Rezoning Transportation Analysis

Petition Number: 2023-011

Revision Log:	Date	Description
	5-24-23	First Review (TM)

The stie is located adjacent to Citadel Place, a City-maintained local street, west of Allen Road, a City-maintained minor collector. A Traffic Impact Study (TIS) is not required for this site due to the site generating less than 2500 daily trips. The proposed site plan will generate less vehicular trips than what is currently entitled under the existing zoning. Site plan and/or conditional note revisions are needed to commit to revising hammerhead turn around to a cul de sac, placing streetscape along both sides of all proposed roadways, revising all internal sidewalk and the addition of conditional notes. Further details are listed below.

TITLE  
PRELIMINARY SITE PLAN  
R-8 (CD)  
RZP\_2023\_011

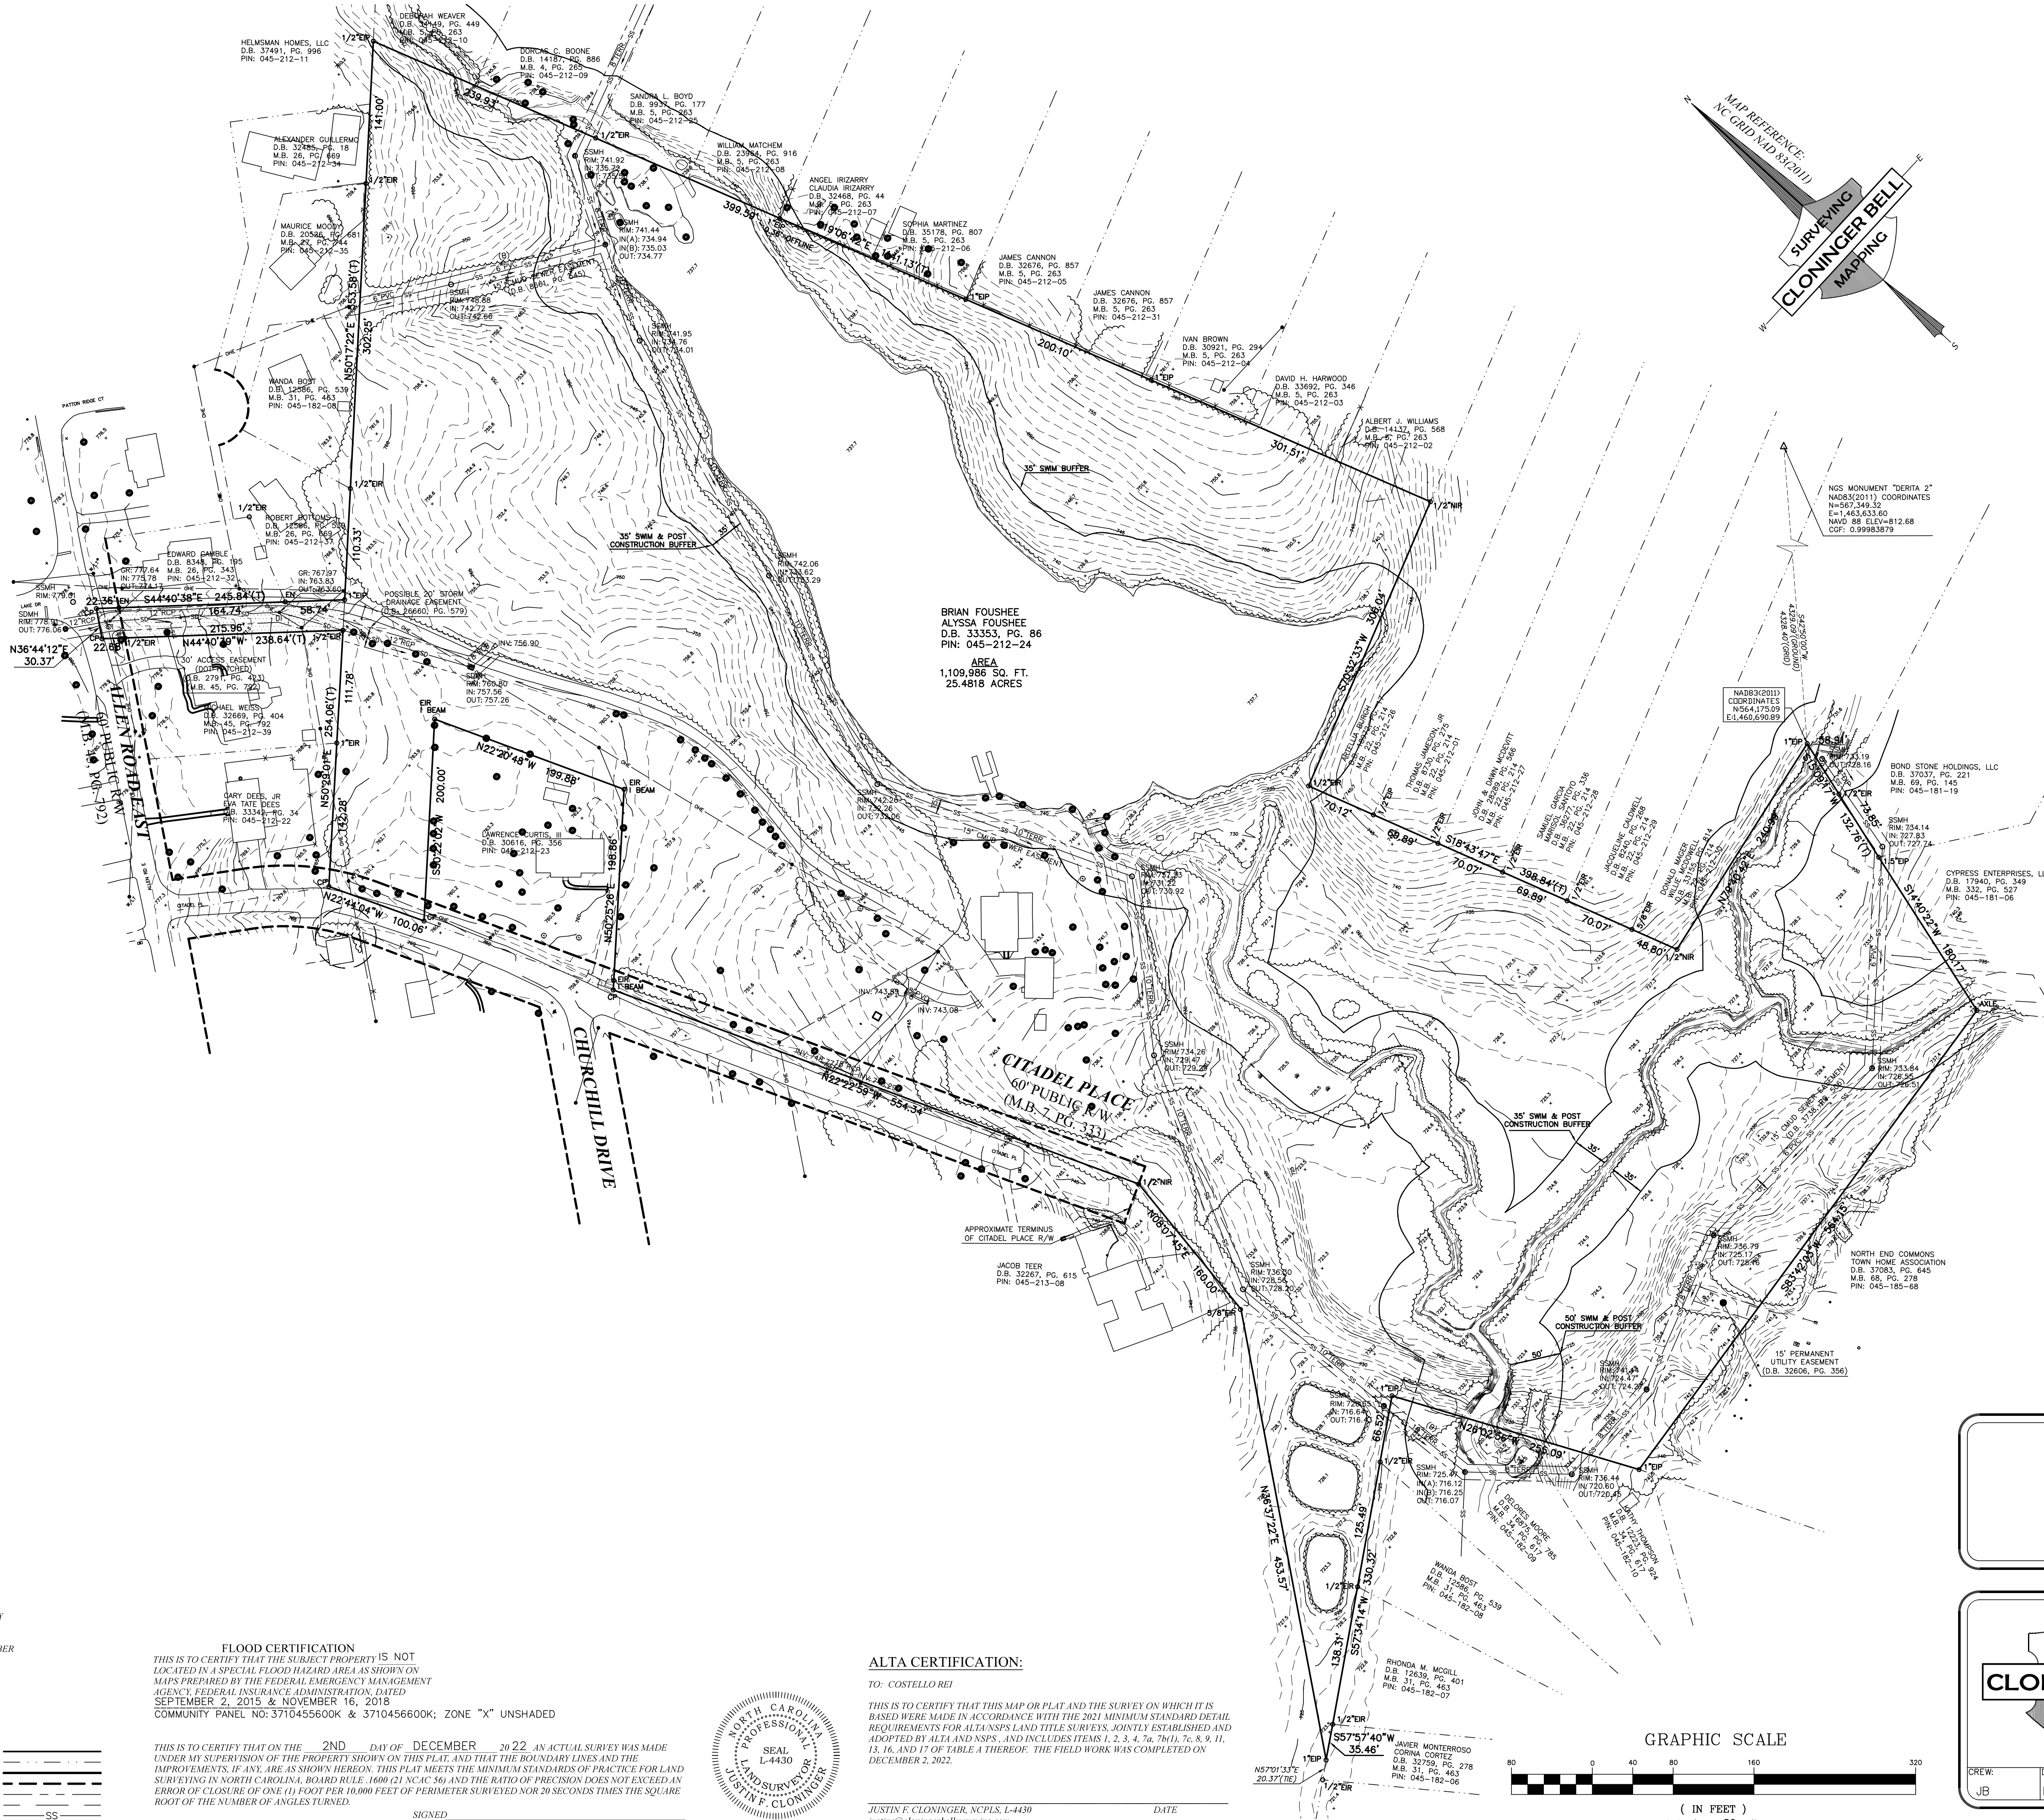
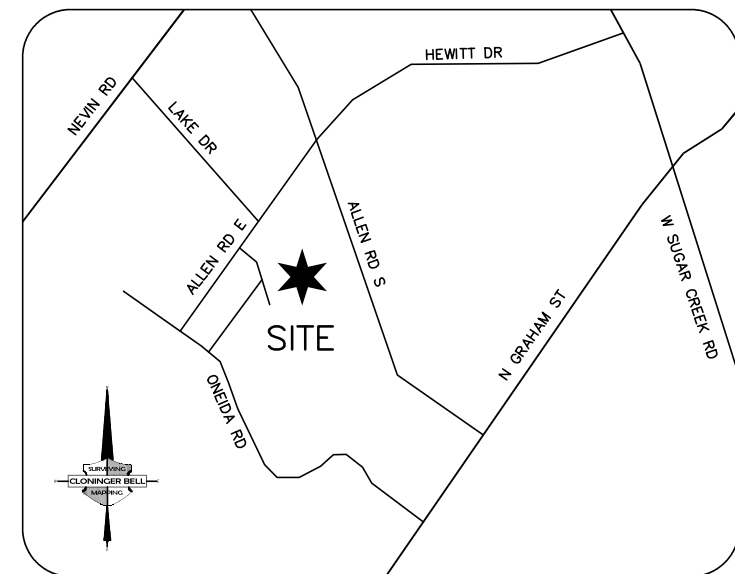
- a. **Citadel Place:** Location of curb and gutter to be moved to 13-feet from roadway centerline to accommodate the Charlotte Streets Map with a roadway typical section of Local Residential medium.

Label and dimension the curb and gutter from the centerline for each road on the site plan.

3. Revise site plan and conditional note(s) to commit to dedicate 30-feet of right-of-way from the road centerline. The site plan shall label and dimension the right-of-way from the road centerline.

4. Revise site plan and conditional note(s) to commit to construct an 8-foot planting strip, and 6-foot sidewalk on all internal roadways Chapter 19. The site plan shall label and dimension both items from the back of curb and gutter or edge of pavement.

6. Revise site plan and conditional note(s) to commit to streetscape along both sides of all proposed roadways.

7. Revise site plan and conditional note(s) to commit to revising the proposed hammerhead to a cul de sac as to not stub to the single family homes to the North of the petition.
